RE: **4936 Pan American**
Grading and Drainage Plan for Grading and Foundation Permit Only
Engineer's Stamp Date: 11/03/17
Hydrology File: F17D032

Based upon the information provided in your submittal received 11/03/17, the Grading and Drainage Plan is approved for Grading and Foundation-Only Permit in support of Foundation Permit 2017-38488. The following conditions apply:

PROJECT TITLE	4936 PAN AMERICAN FRWY NE	DRAWN BY:	OLIVIA WOOTEN
	MCLEOD AND P25	JOB NO.	2017018
	ALBUQUERQUE, NEW MEXICO 87120	PROJECT MANAGER	JEFF WOOTEN
		SHEET TITLE	Grading Plan

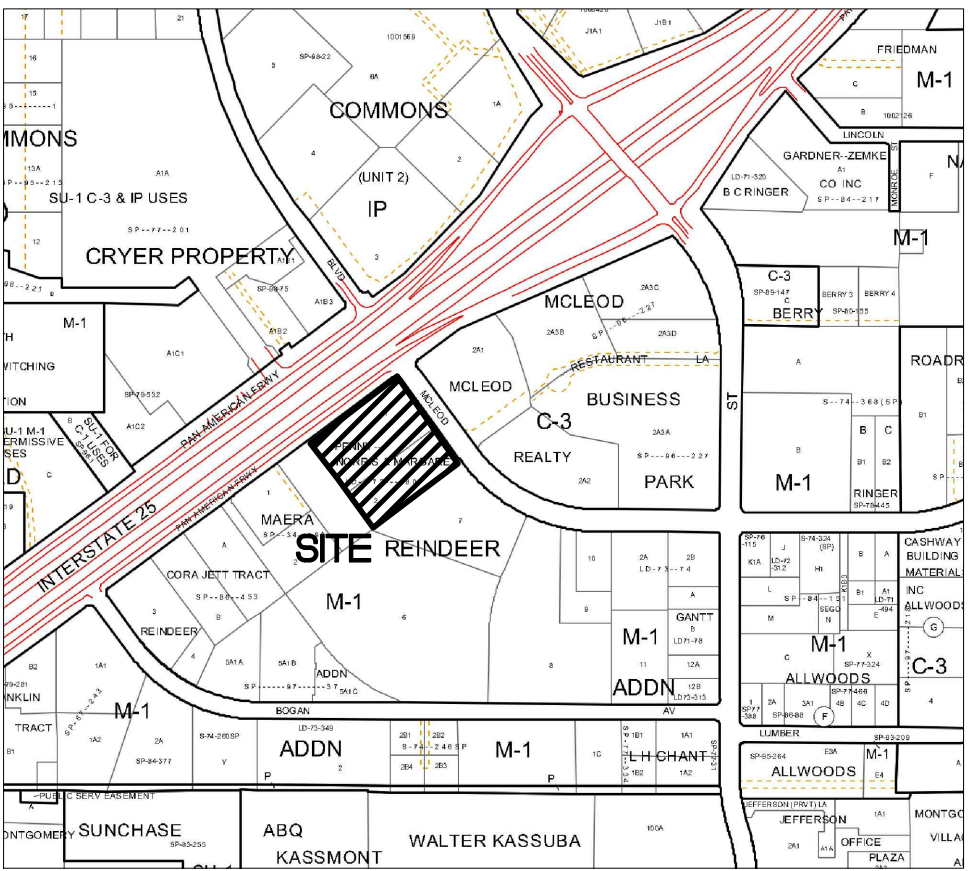
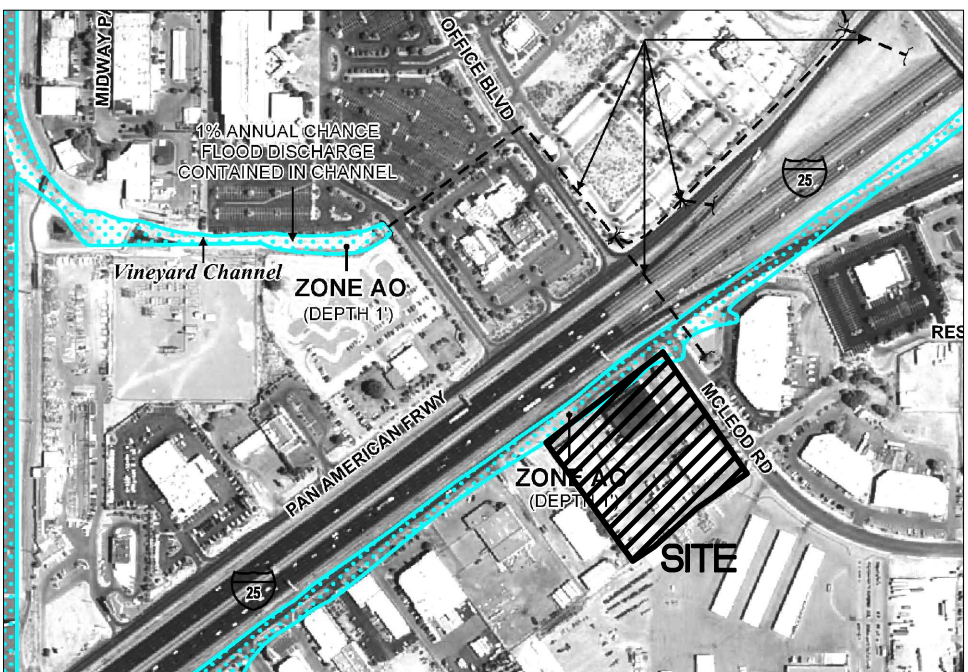
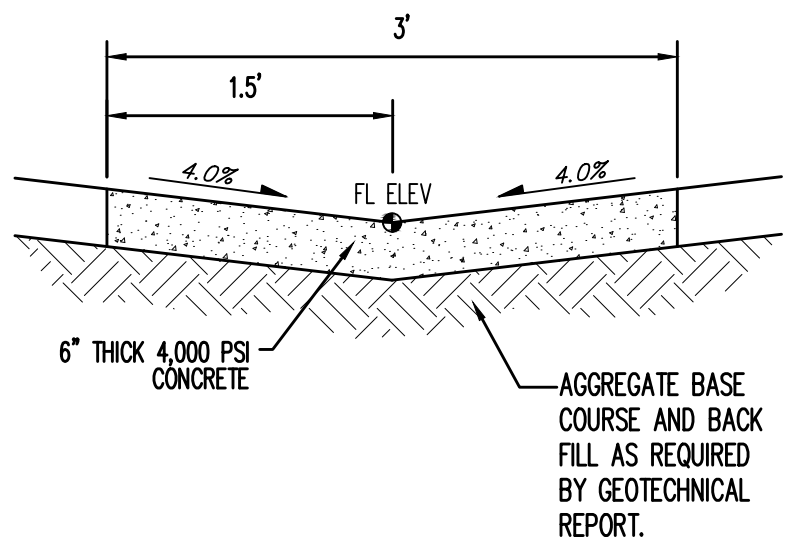
1. Grading and site work within the clouded area along McLeod and Pan-American is not permitted with this approval; a separate grading plan and permits will be required for this work to address floodplain management.
2. Paving and vertical construction are not permitted as part of this approval.
3. Work under this approval is at the owner's risk with the understanding that the plan is changing and new construction may have to be removed and re-constructed to comply with the final grading plan.
